CITY OF ALBUQUERQUE

October 11, 2024

RE: Sawmill Tract J – 800 20th St. NW
Grading Plan and Drainage Plan
Engineer's Stamp Date: 09/30/2024
Hydrology File: J13D076B

Based upon the information provided in your submittal received 10/01/2022, the Grading & Drainage Plan is **not** approved for Building Permit, Grading Permit.
Please address and respond to the following comments and resubmit accordingly.

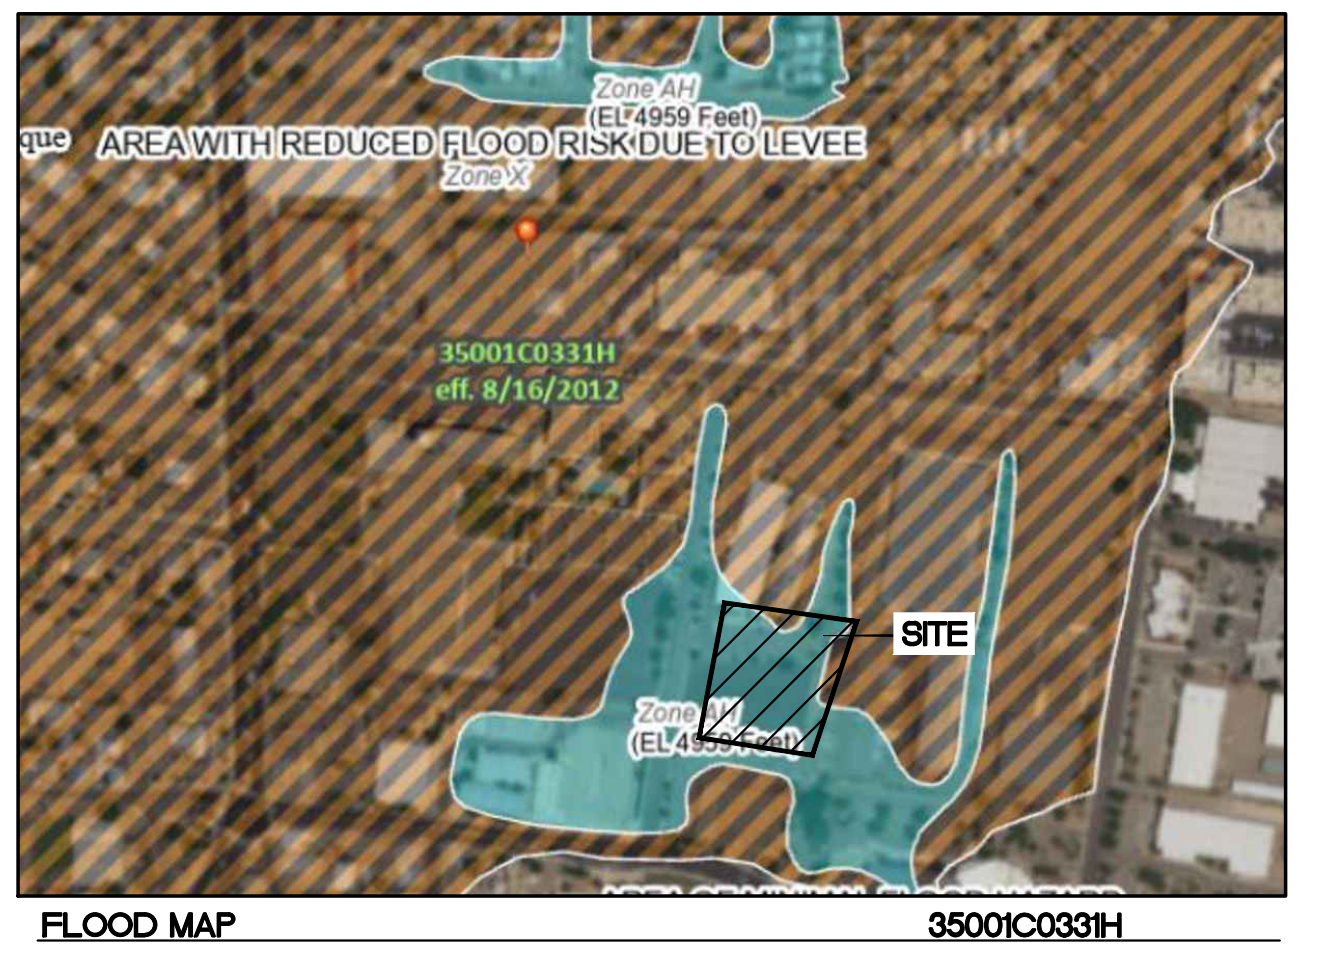
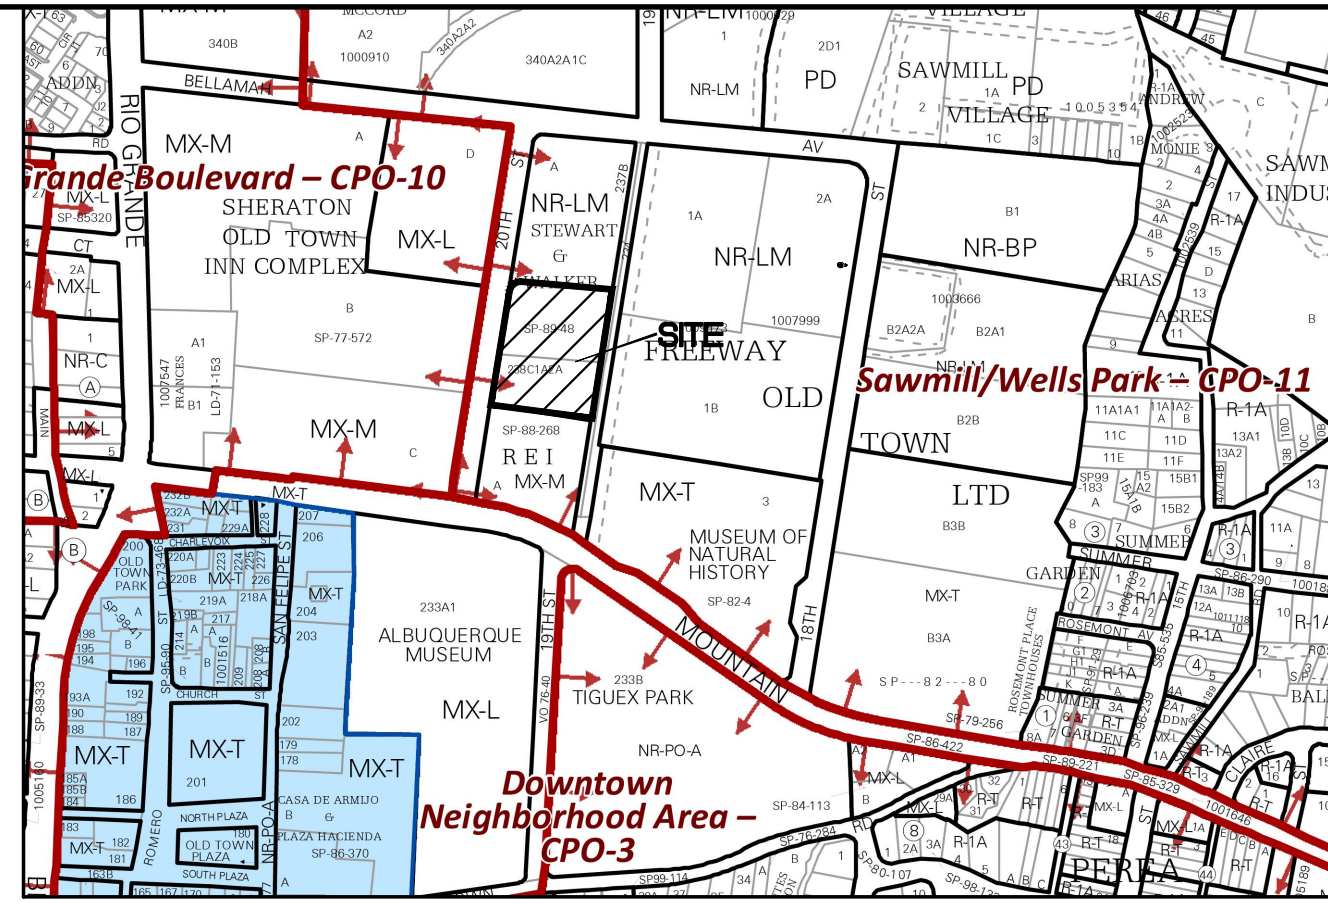
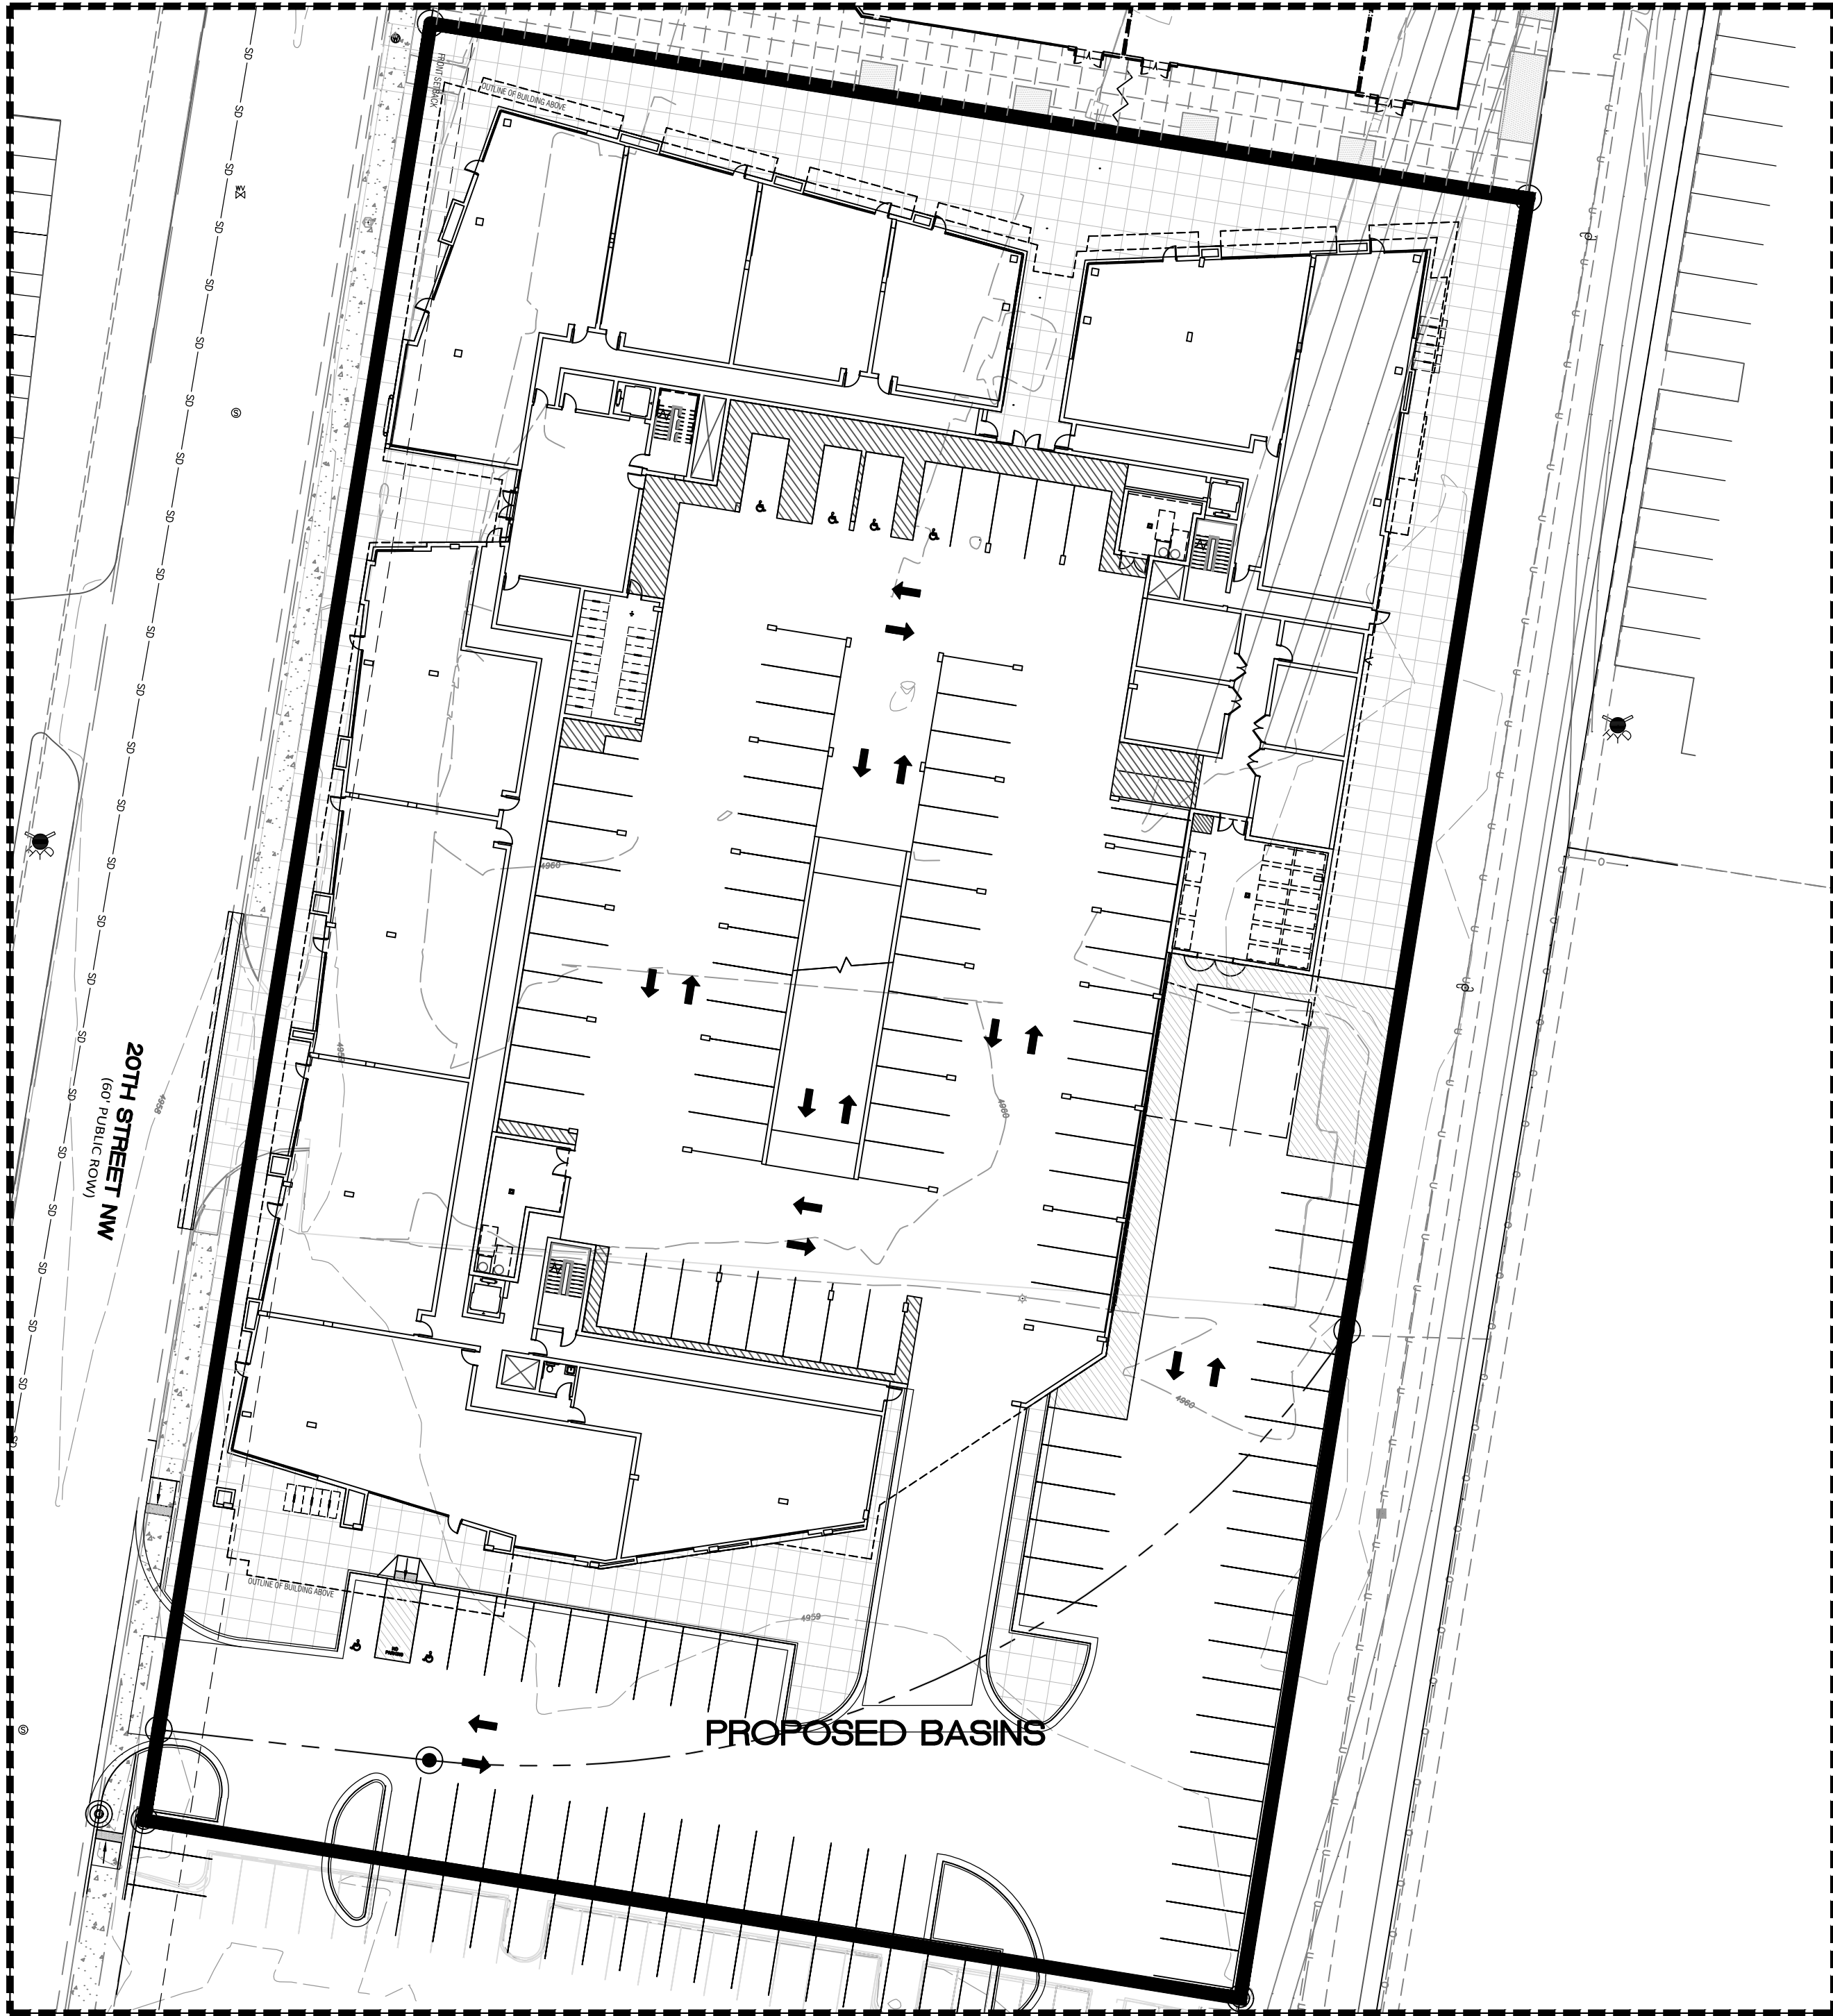
1. Sheet GR-1 – Please review and revise the Proposed Drainage narrative to include, a) which basin drains to 20th St., b) the storm water from roof drains and area drains routed to the proposed 33' x 85' Underground Detention Facility (provide calculations to confirm capacity), c) identify proposed outfall configuration of said Detention Facility with calculations, and d) identify and label the existing inlets on 20th St.

2. Sheet GR-1 – Please review and revise the Proposed grades along the east side of the proposed 2' landscape area along 20th Street, there is an 0.92' drop along its alignment which may impact the roof drain from the adjacent building to the proposed 10" PVC pipe.

| | | SHEET # GR-2 |

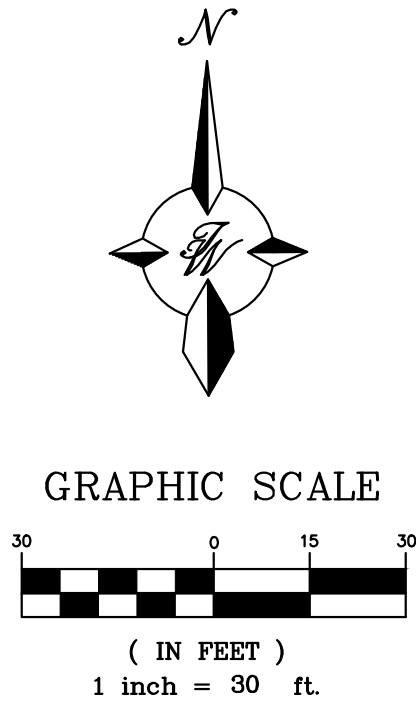
3. Sheet GR-2 – Please review and revise the Proposed Basins layout to identify all Basins and expand layout to show information on RD manholes, and appropriate inlets on 20th St.
